Development Control  
Ribble Valley Borough Council

Your ref: 2018/0435  
Our ref:  
Date: 21/09/2018

**Re:** Planning Application 18/0435

**Address:** 32 Hall Street Clitheroe BB7 1HJ

| Project No: GRAHA/01 / DWG 01C |   |   |   |  |  |

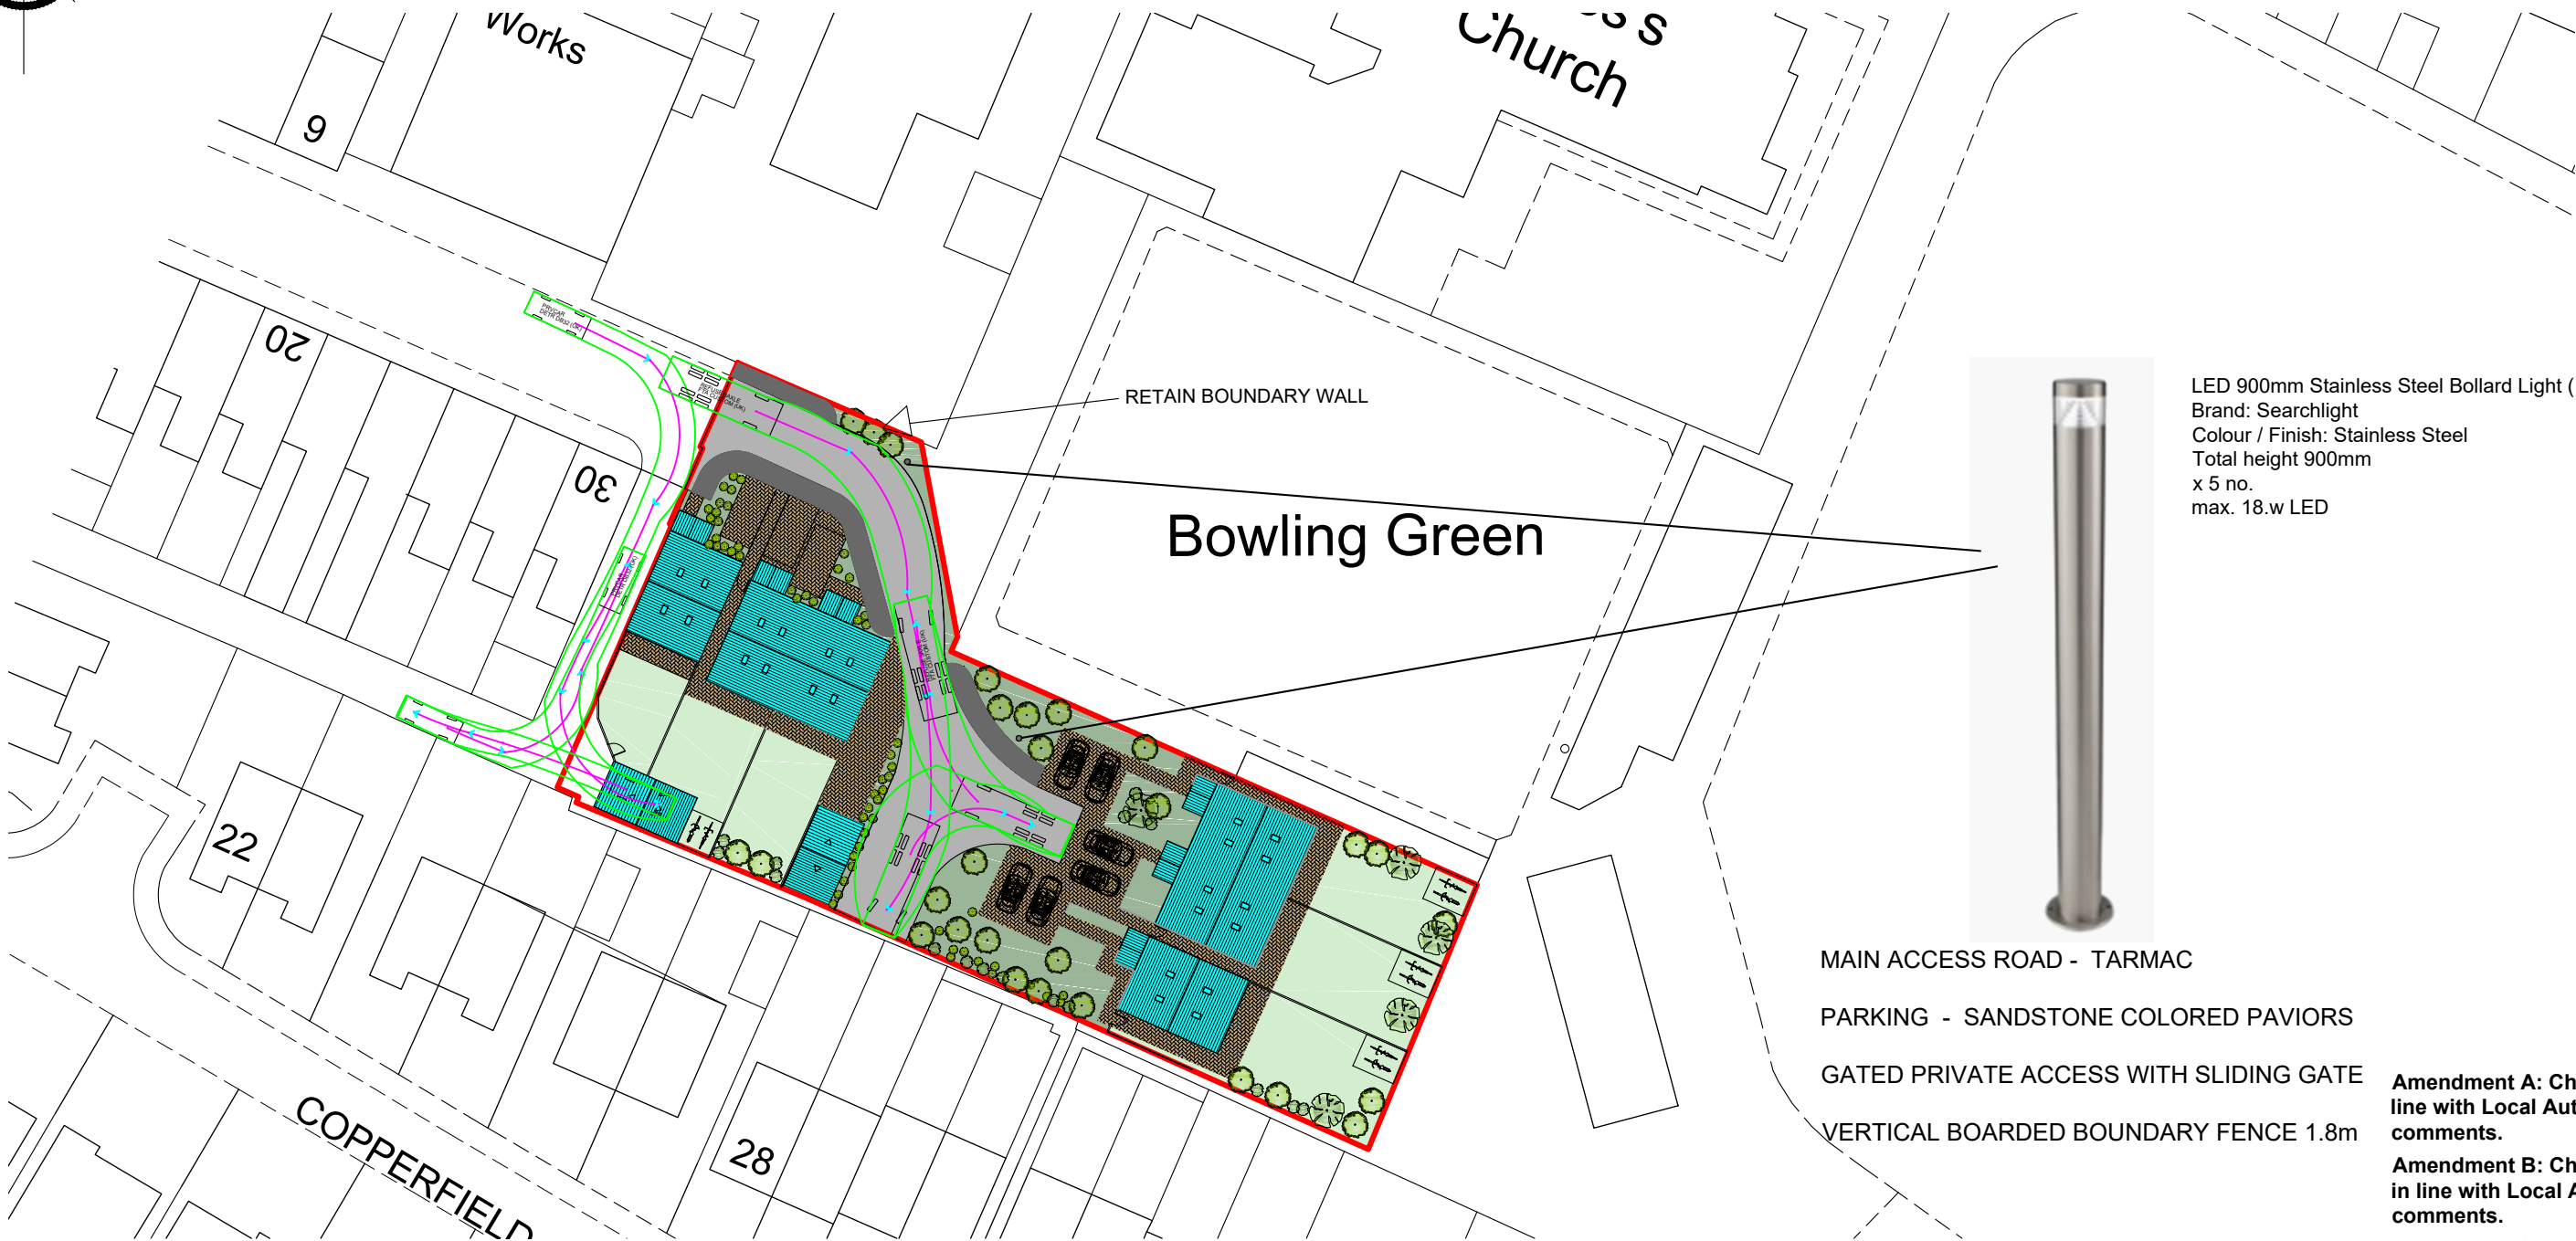
With respect to this application we would not wish to raise any objections. This is based on the details of the plan numbered GRAHA/01 / DWG 01C dated 19/09/18

This plan provides for garages for Plots 1-2, and the removal of the parking spaces to the front of the properties. All of the proposed garages are sufficiently large enough to be counted as parking spaces and should remain as such for the perpetuity of the development.

The parking space in front of plots 4-6 have also been altered from the initial submission access, although it is expected that they will still function.

- There has been no indication regarding the provision of any surface water drainage.
- Although some street lighting has been shown it is not expected to have achieved any recognised lighting class under BS5489
- The swept path analysis undertaken to ensure that a refuse collection vehicle can enter and exit the development in a forward gear has only been shown in one direction, this may not be the preferred direction by the driver this should be repeated in the other direction.
